Recommendation Report for Planning Permission

REF NO: BR/242/18/PL

LOCATION: DD Motors
Bersted Street
Bognor Regis
PO22 9QF

PROPOSAL: Single storey side extension.

Title
PROPOSED GROUND FLOOR PLAN

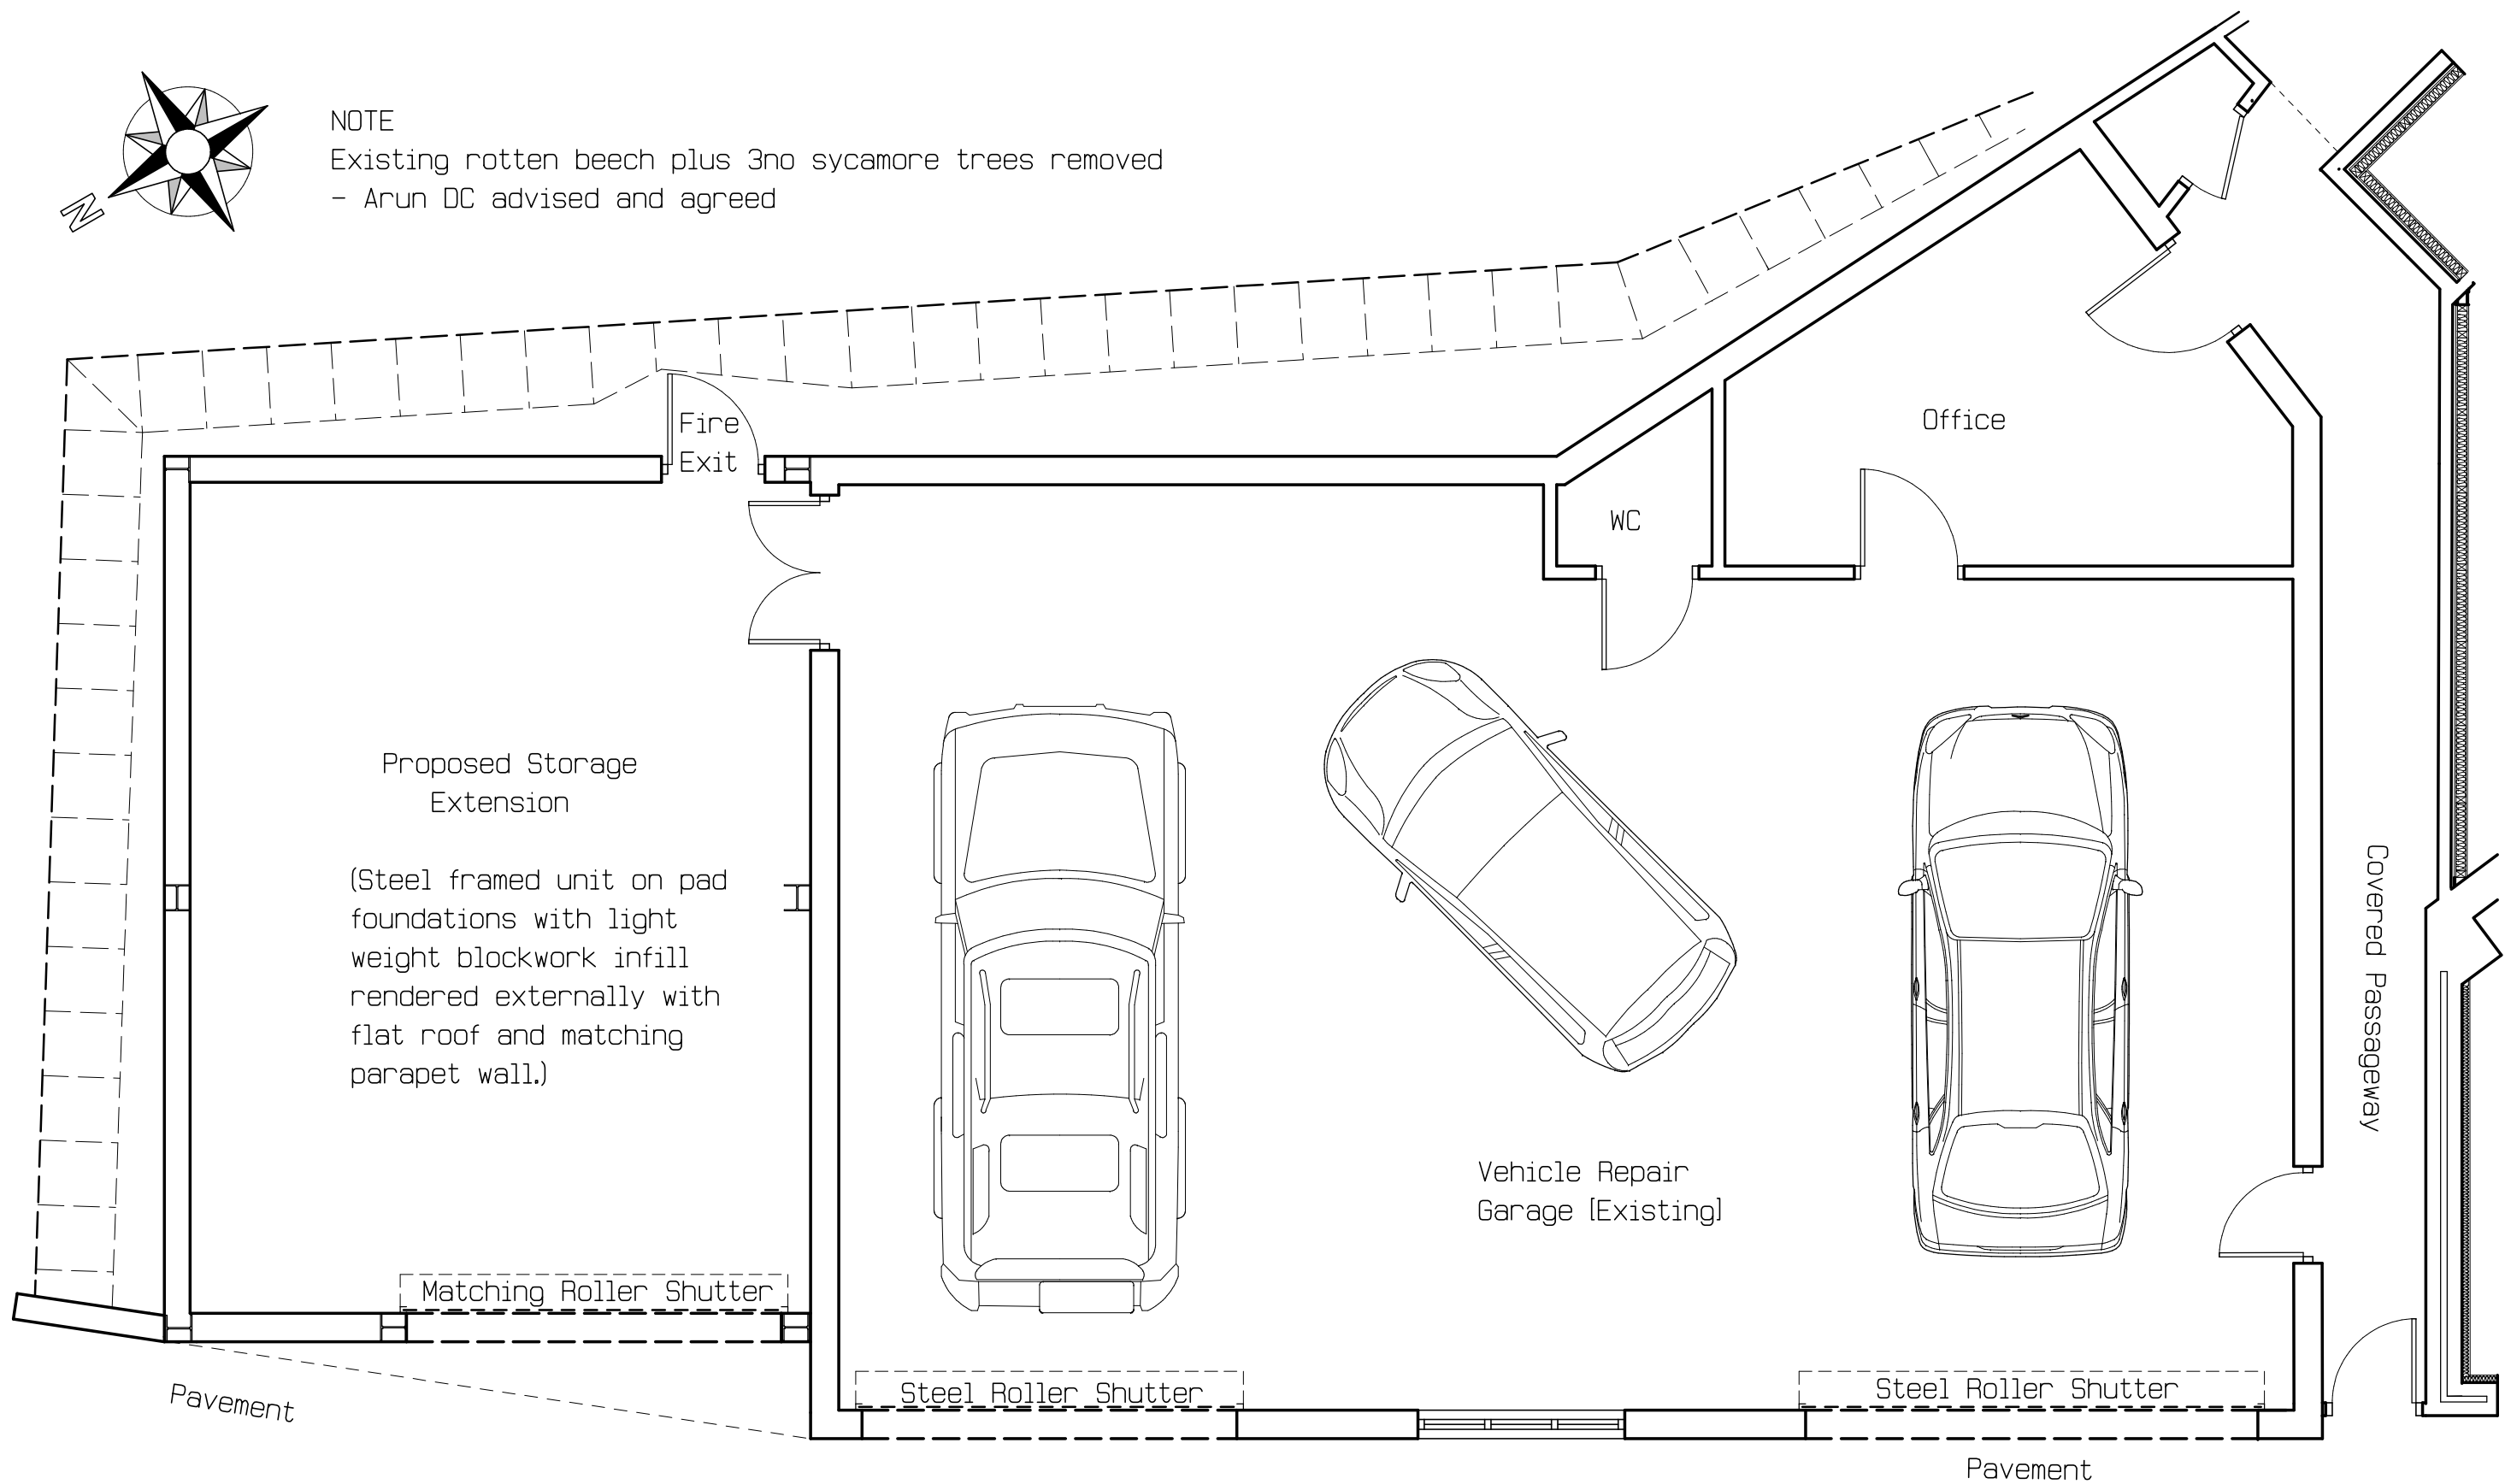
Constructed with steel frame unit on concrete pads with lightweight blockwork infill in order to minimise any impact on trees and their roots.

Title
PROPOSED ELEVATIONS

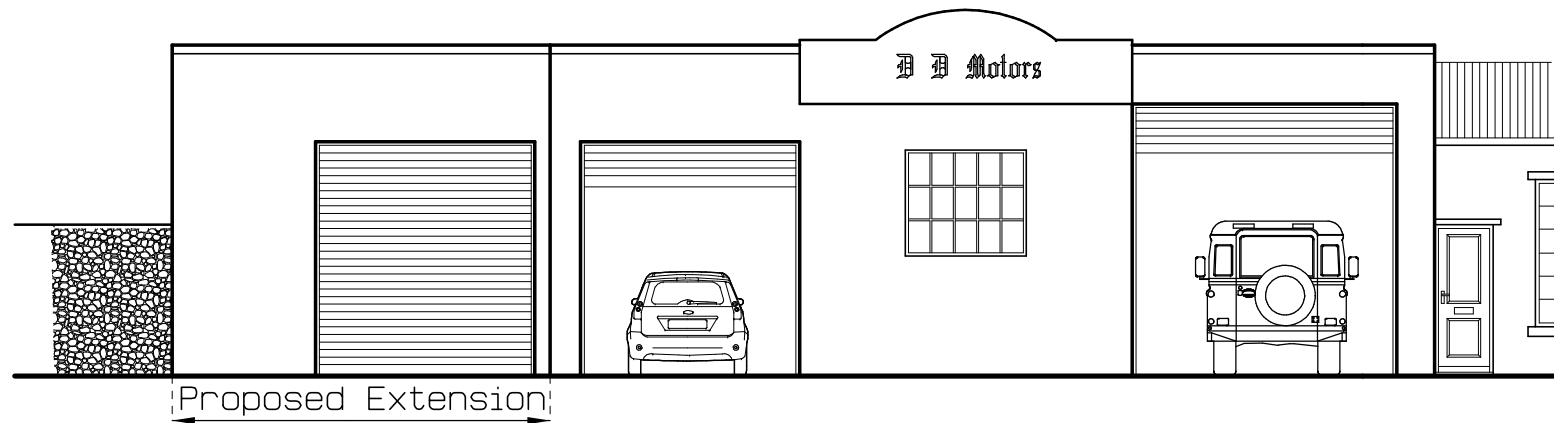
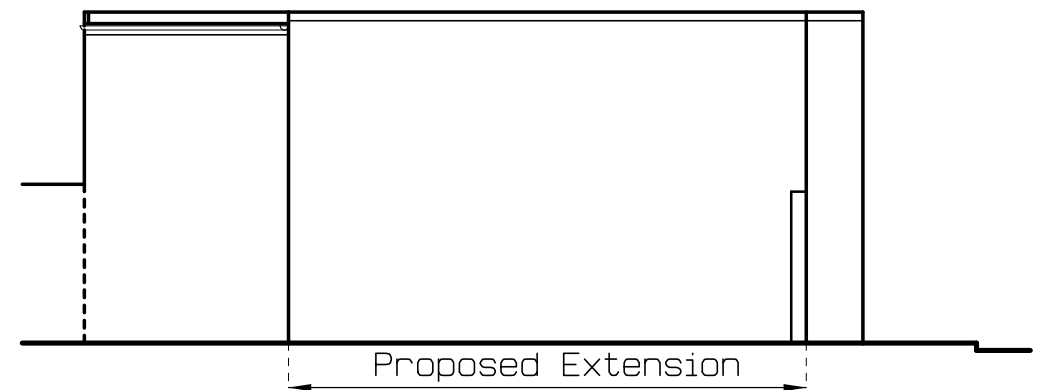
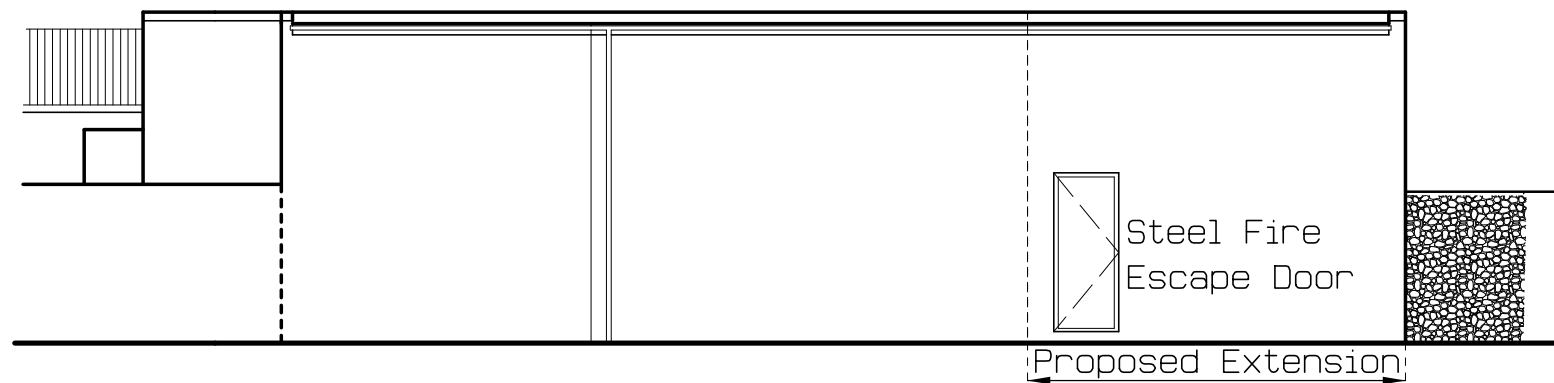
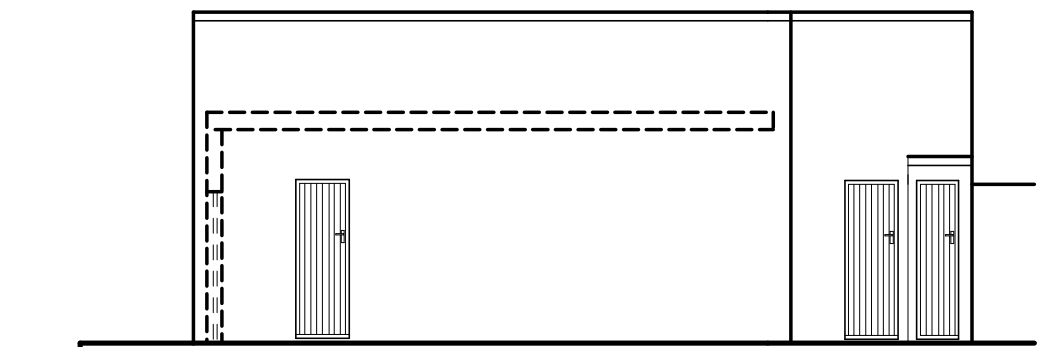
The applicant will need to apply to the area highway office to have the kerb dropped in front of this new roller door.

From an assessment of the plans and Officer's site visit the proposed single storey side extension, would be acceptable in design terms as it would be of a size and scale that harmonises with the host building. Therefore, the proposal would not be unduly prominent or out of keeping with the design and external appearance of the application site with regard to its size, scale and massing.

Officers note the removal of a section of flint wall to the front of the site. From an assesment of the plans

Officers consider that approximately 2.8 metres of the wall would need to be removed in order to accommodate the proposed extension. As stated in the OFFICERS COMMENTS OF REPS section above, it is considered that the proposed removal of 2.8 metres of the flint wall would not have a detrimental impact on the amenity of the area and as such the application should not be refused on this basis.

No windows are proposed into any elevation of the proposal, with only a roller shutter garage door proposed into the front elevation. Therefore, should the Roller shutter door be open views would be available out toward and over the existing highway, an area that is already significantly overlooked. Officers therefore consider that no materially harmful levels of overlooking would occur as a result of the proposed extension.

Title
PROPOSED BLOCK PLAN PLUS EXISTING
AND PROPOSED FLAT ROOF HIGHLIGHTED

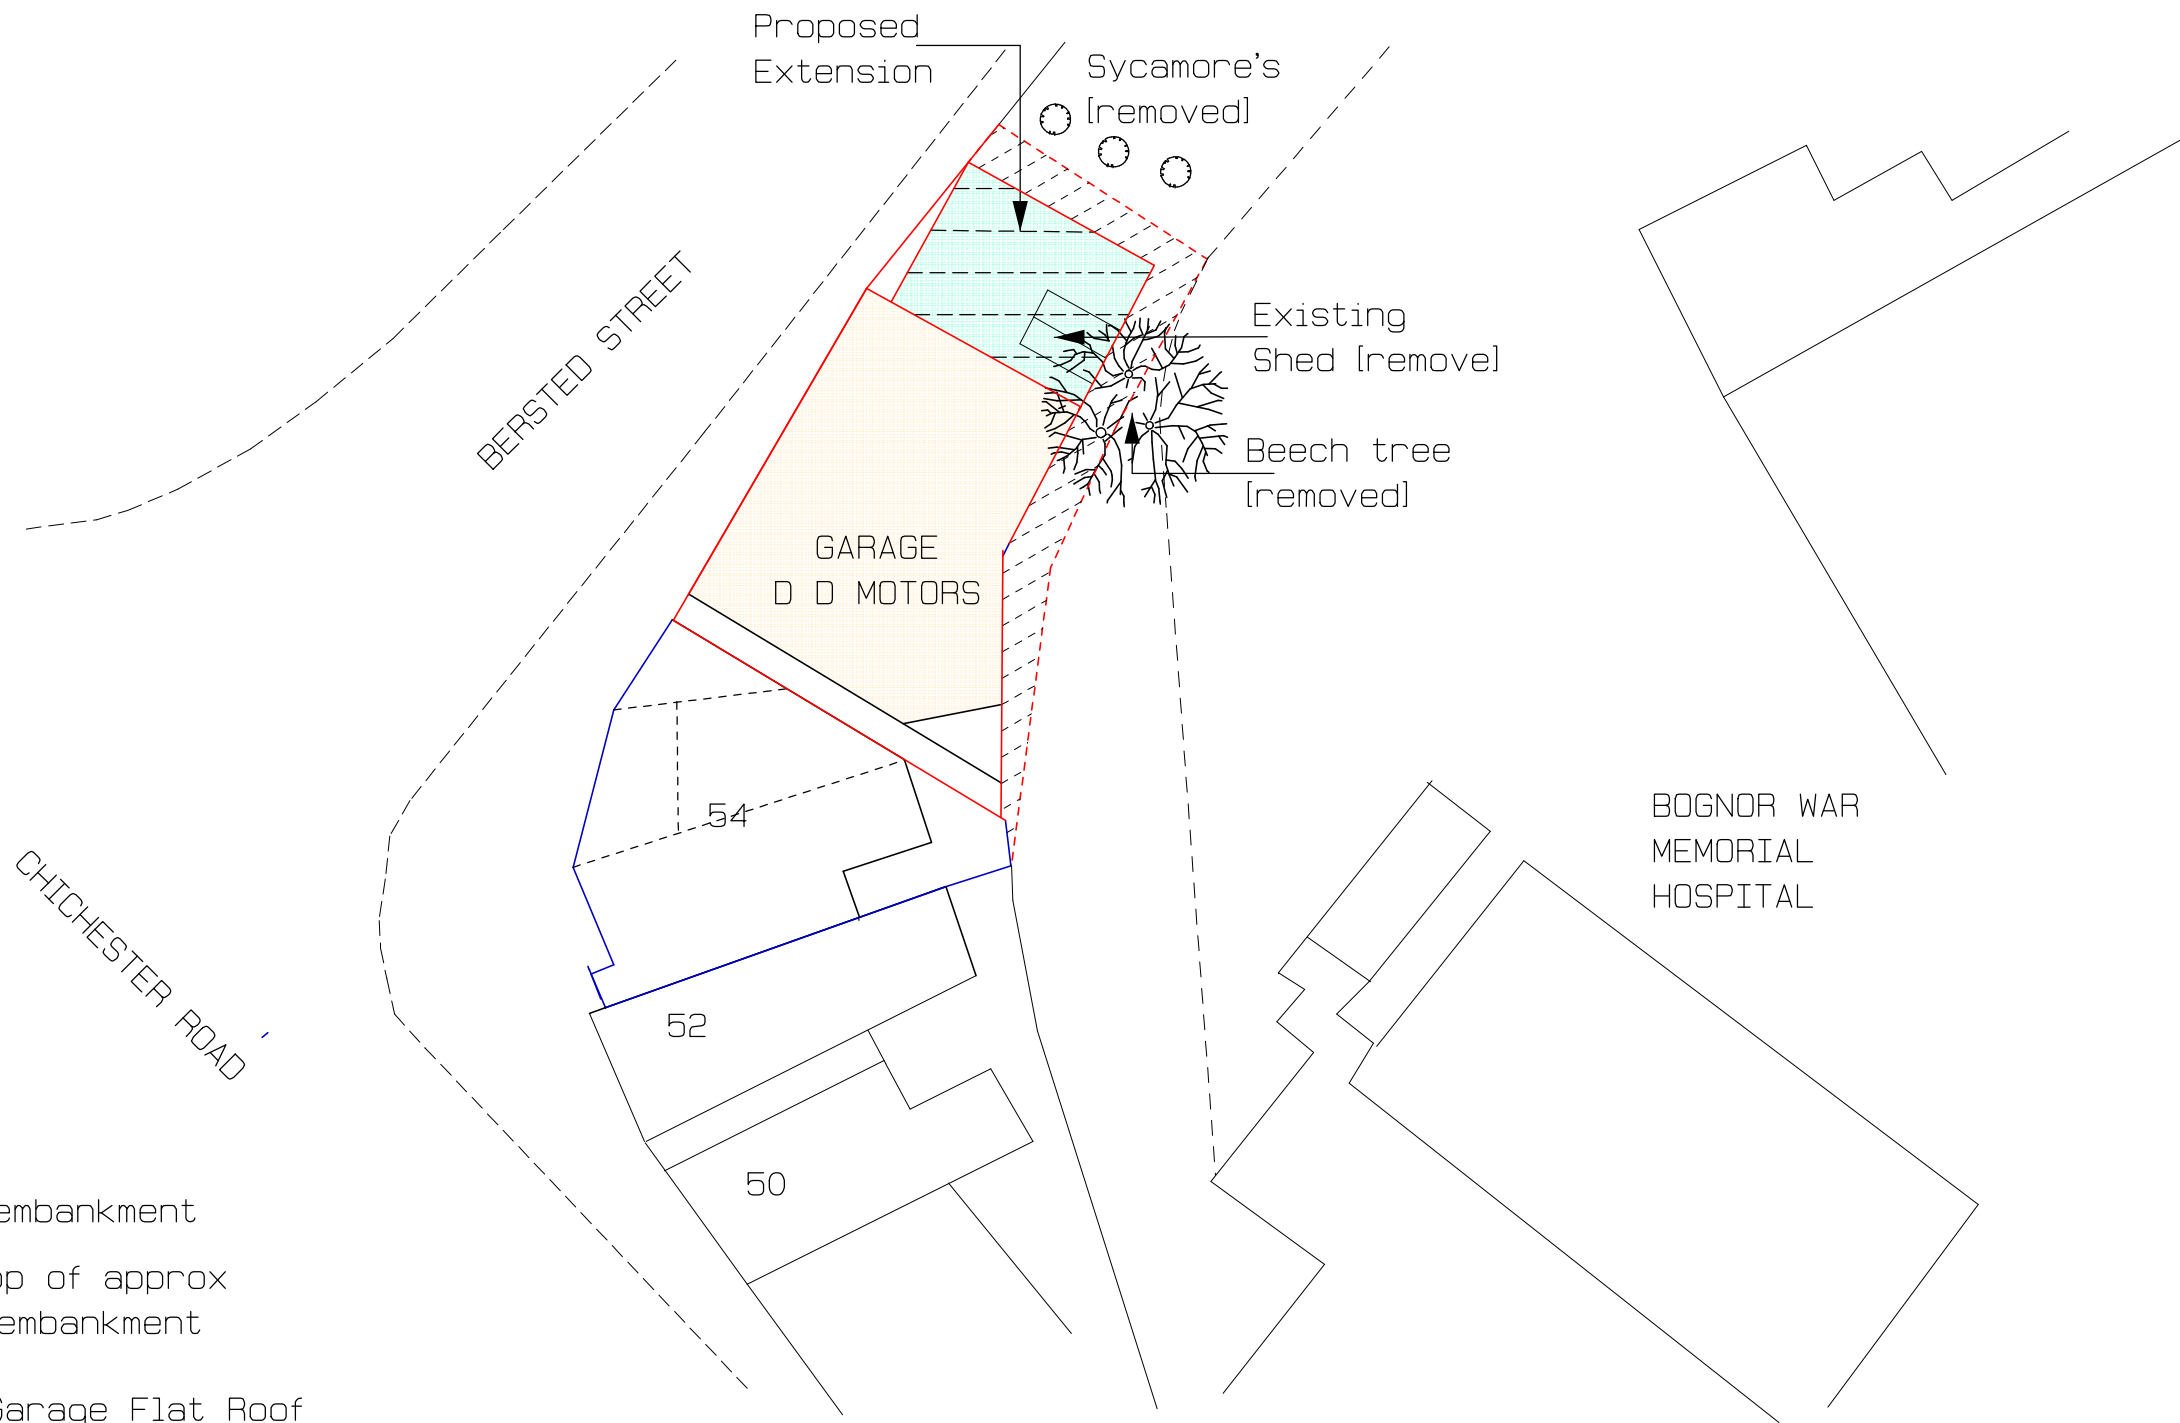
It is unclear from the location plans where there will be room to locate a soakaway that is 5m from buildings. It may be necessary for the surface water to connect into the surface water sewer, the necessary approvals from Southern Water will be required for this.
